Rep for BR/75/20/HH

Subject: Application PP-08589020.

Revisions:

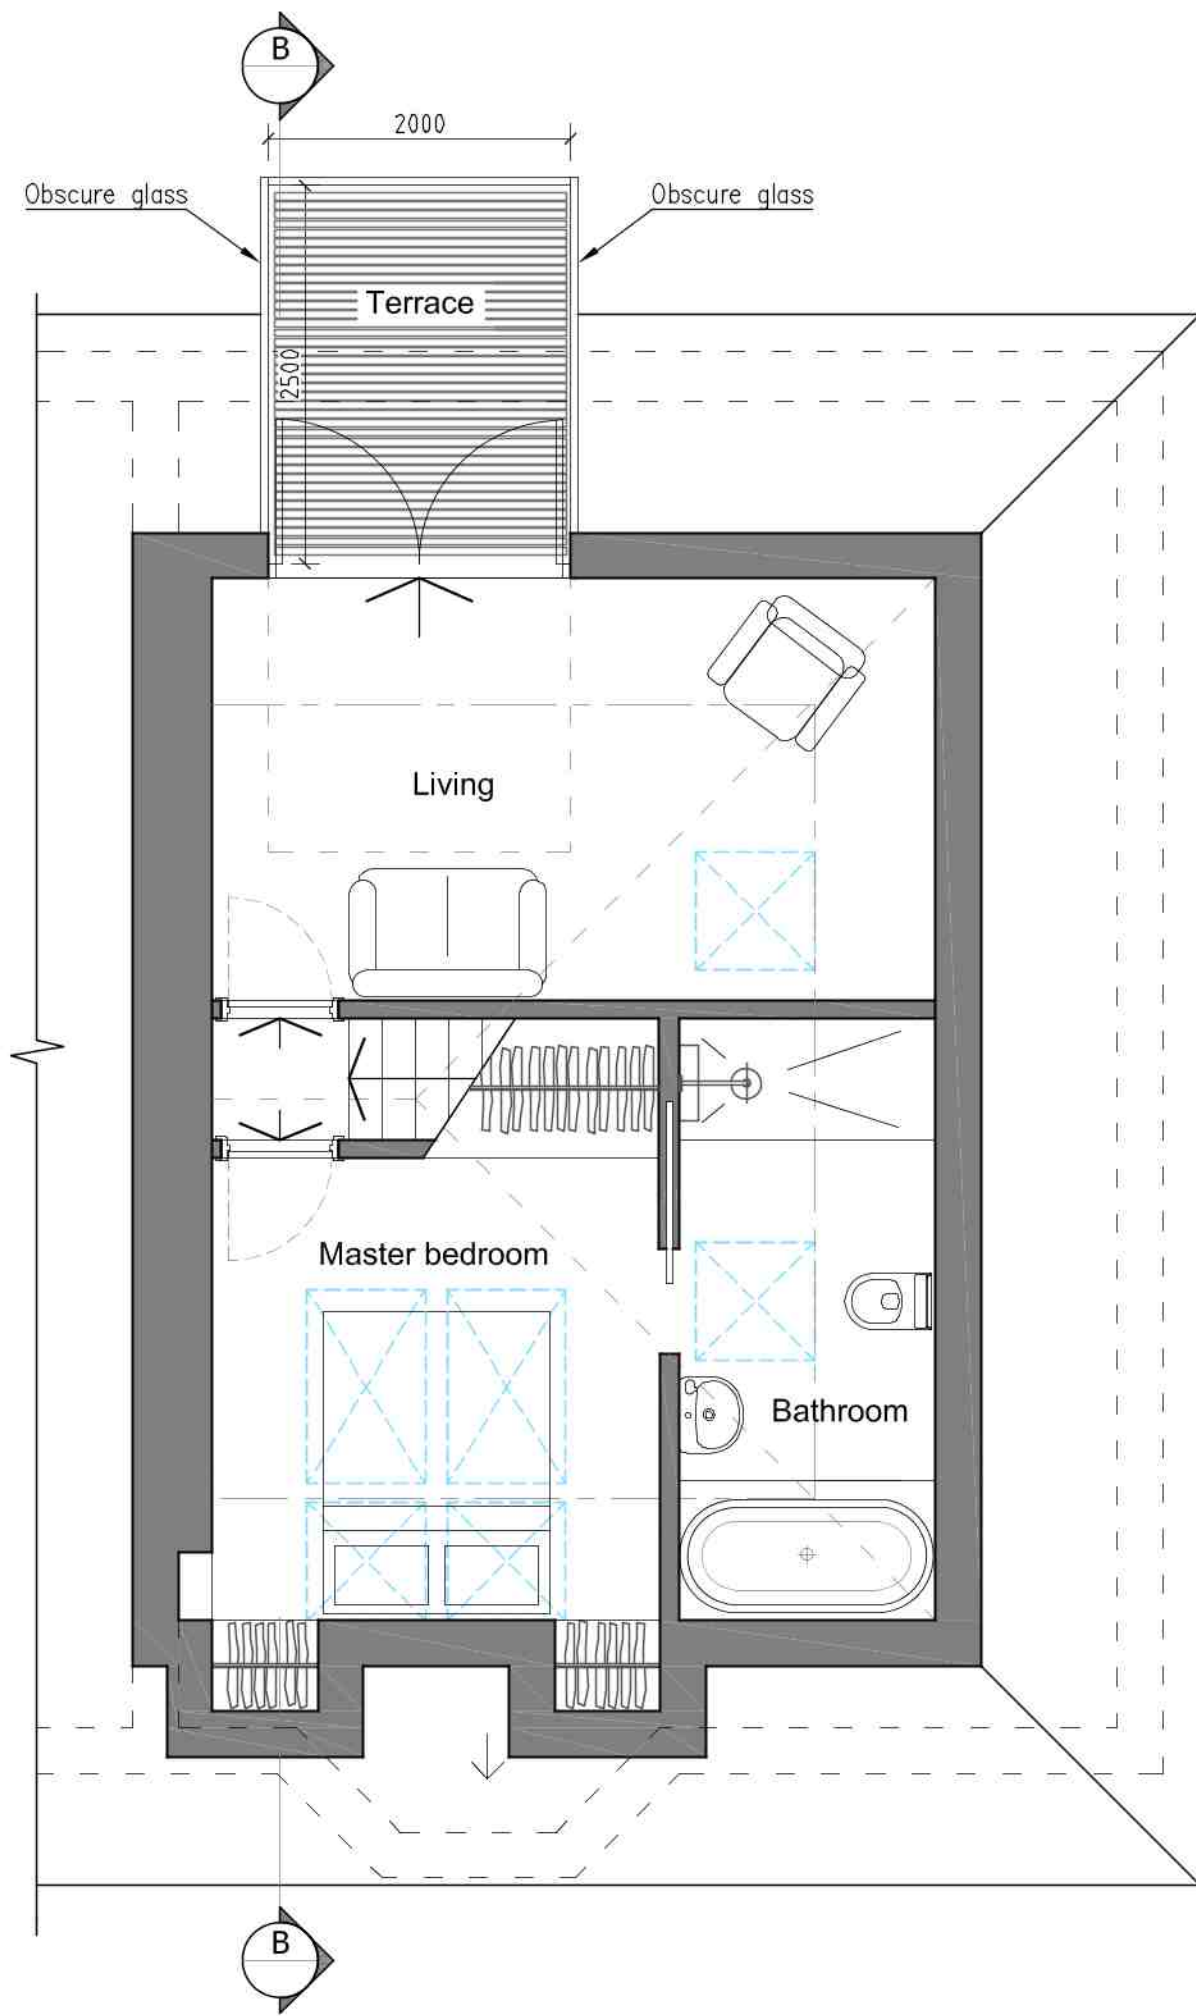
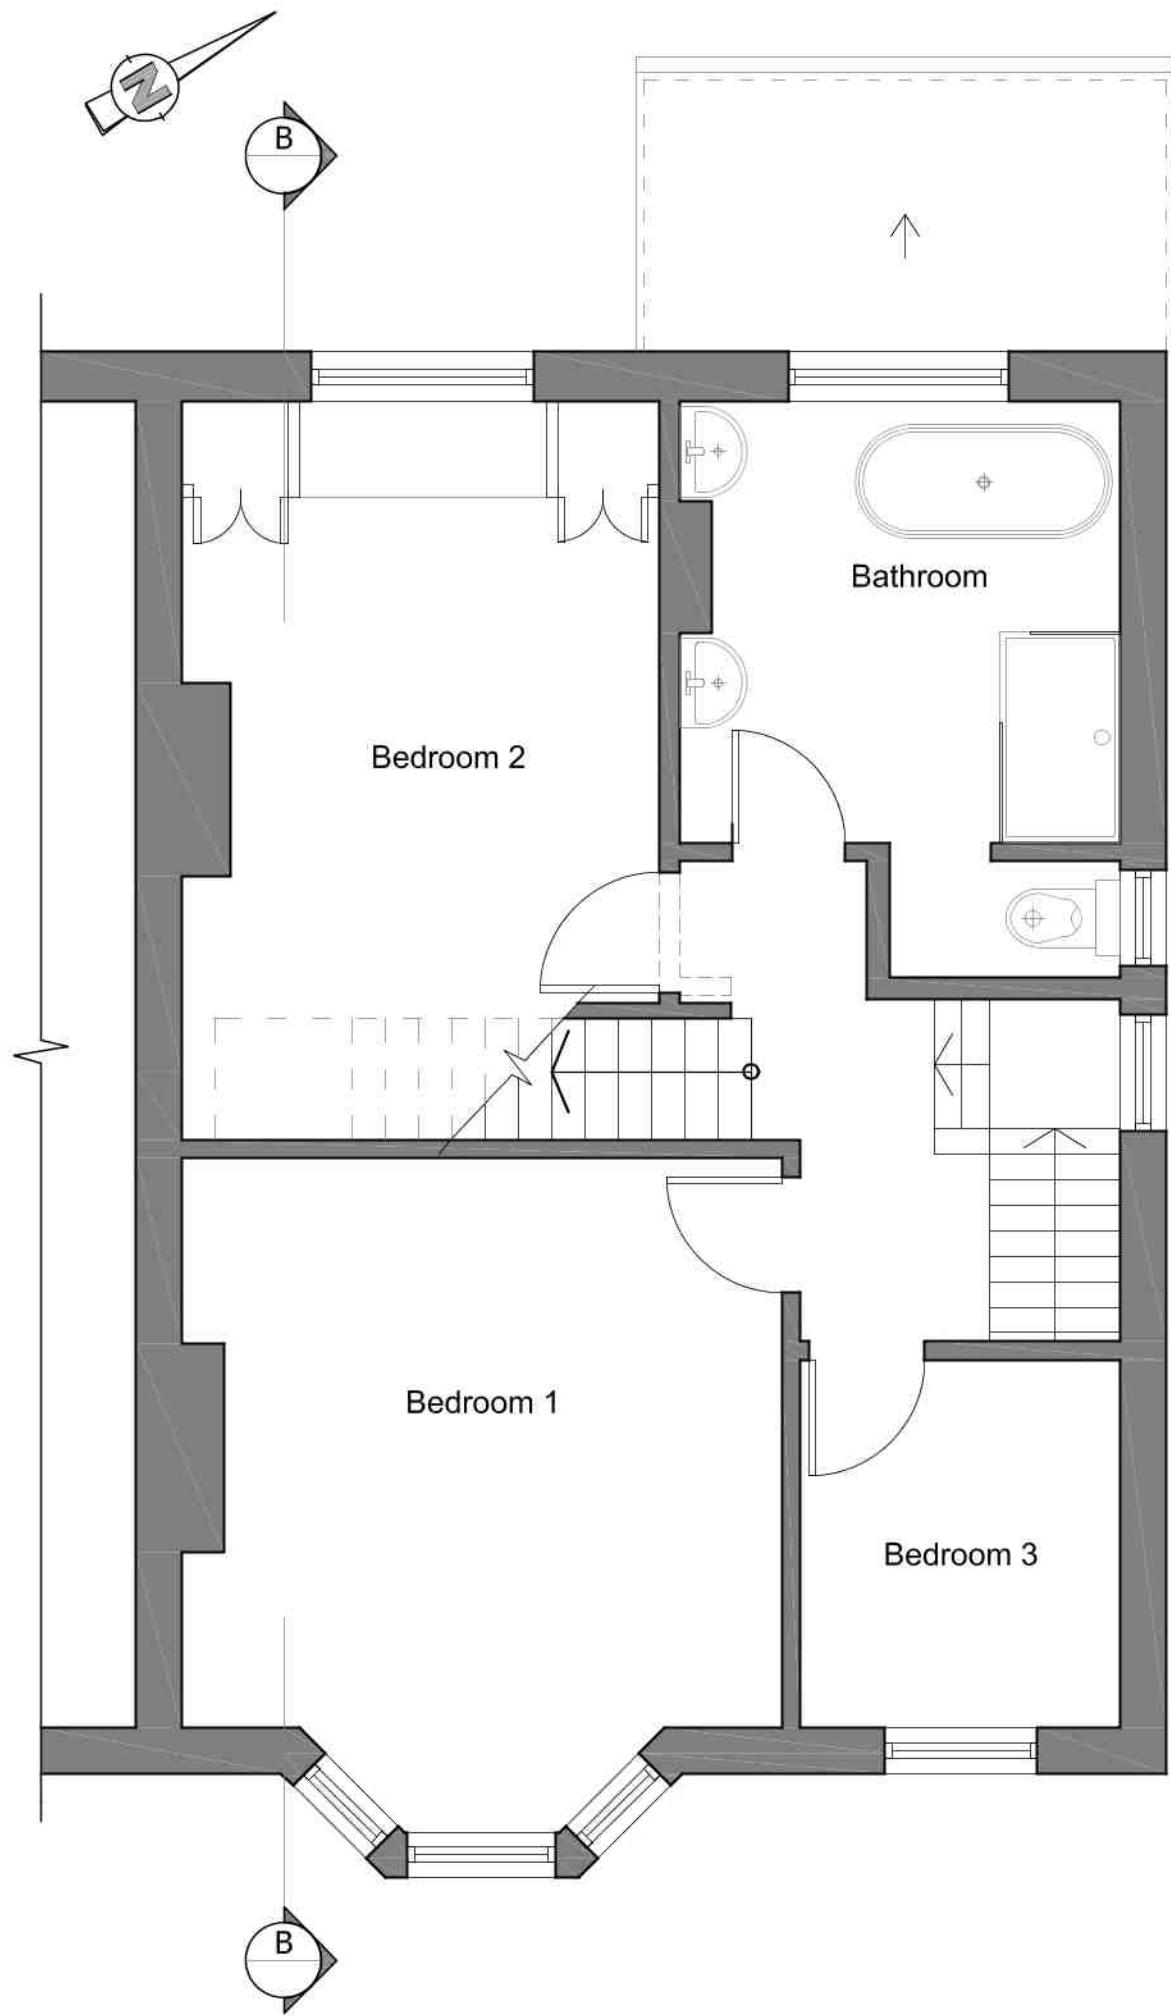
My name is Mrs E Steel.I want to lodge an objection to the above application. I live in Spencer St almost opposite No.140. My concern is my privacy. From the proposed balcony you would be able to look into my bedroom,dining room,garden and conservatory.
